Response to Planning Application

From: Arun District Council Greenspace

Application ref: Y/18/20/PL

Description: 6 No. residential dwellings & associated infrastructure. This application is a Departure from the Development Plan.

scale	date	job no.	dwg no.	rev.
1:500 @A2	NOV. 19	1910	2.01	A

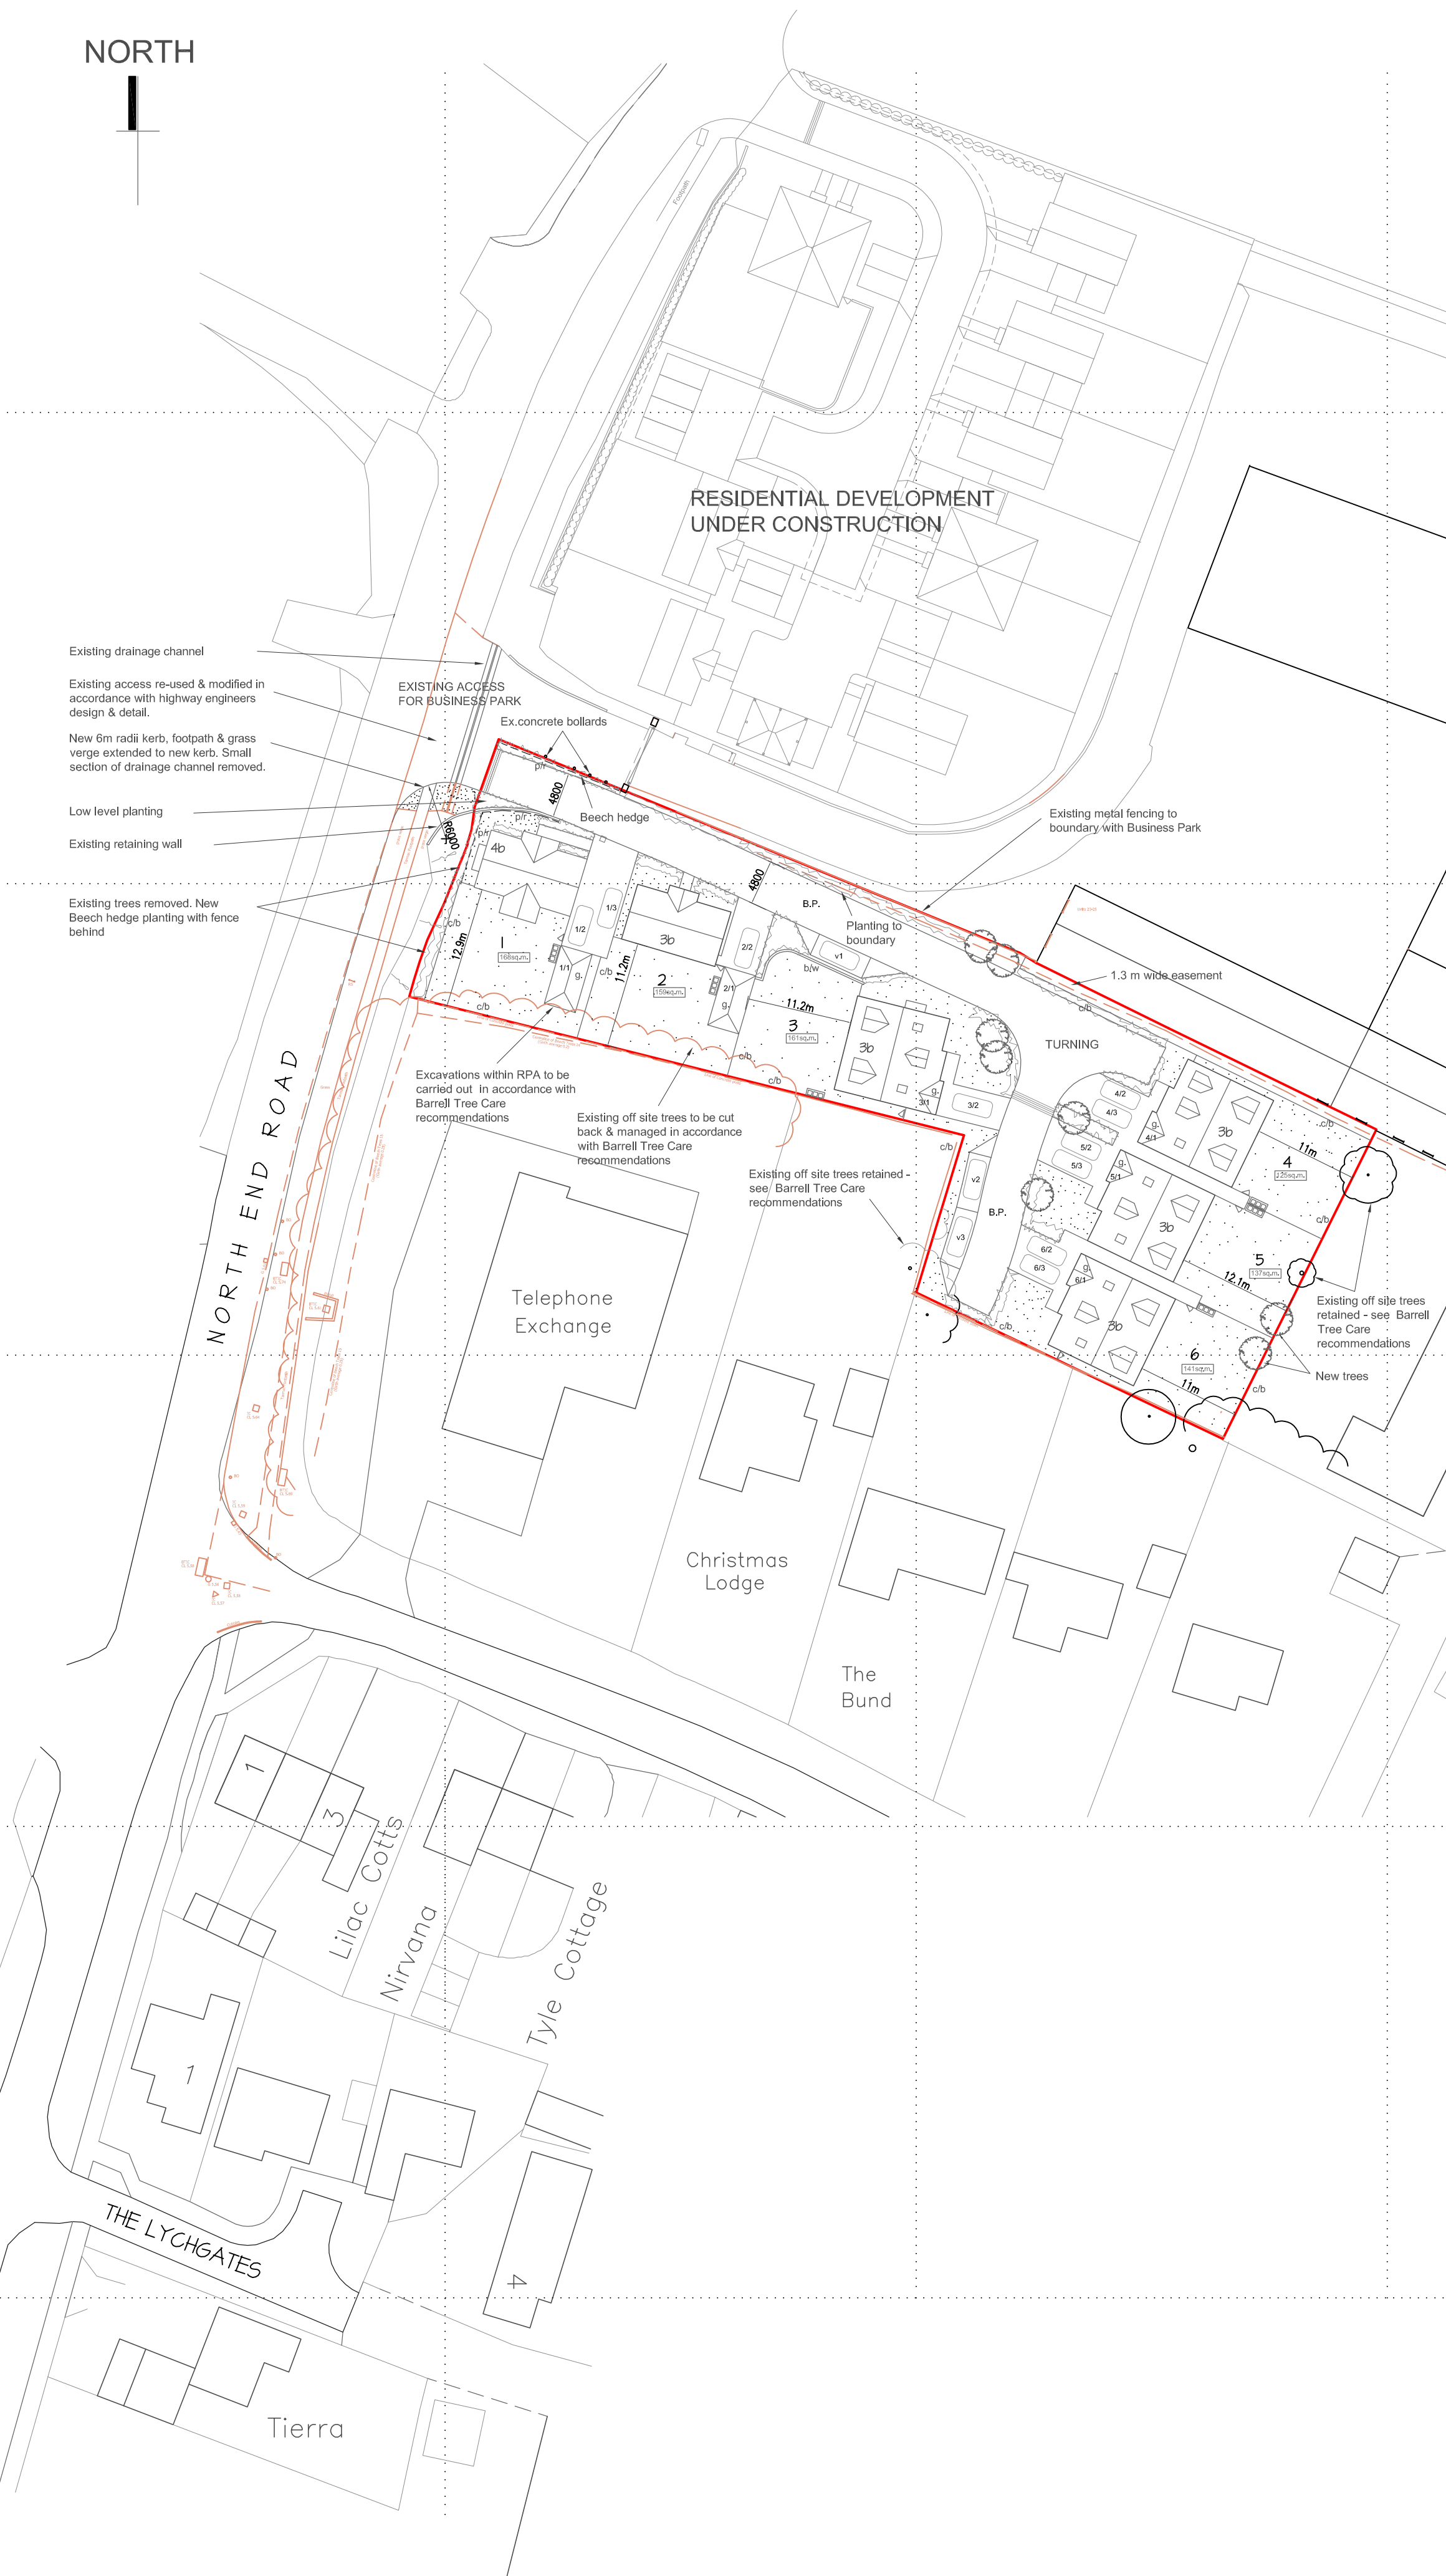
The NPPF para 124/127 relate to good design principles which equally apply to small infill development. The indicative landscape proposals in Crossley Design Site Plan 2.01 Rev A has made brief reference to indicative planting and offsite tree retention. These details would require expanding in the form of a detailed planting plan and specification detailing species choice, actual plant quantities, planting densities and size at time of planting. Detail should also be provided regarding existing hedgerows within the site which provide important bat commuting and foraging potential. Offsite existing trees will also need to be protected from root incursion and details re the protection of these to be provided and approved.

Whilst this could be an overdevelopment of the red edge plot, the potential impact of the proposals could be blended into the surrounding environment with further thought given to the landscape offer and greening to counteract this.

Landscape provision to the dwelling frontages and improvement with native species infill of the existing hedgerows to be provided. All proposed planting should be considered and its connection for biodiversity and habitat explored. Trees specified should be at a size which allow instant impact, but which will establish and mature as the site develops.

I would recommend no landscape objection to the proposals subject to submission of landscape details to provide ornamental and native improvements and potential biodiversity gain. To confirm tree protection methods in relation within and beyond the site boundary that may be affected by the development proposals.
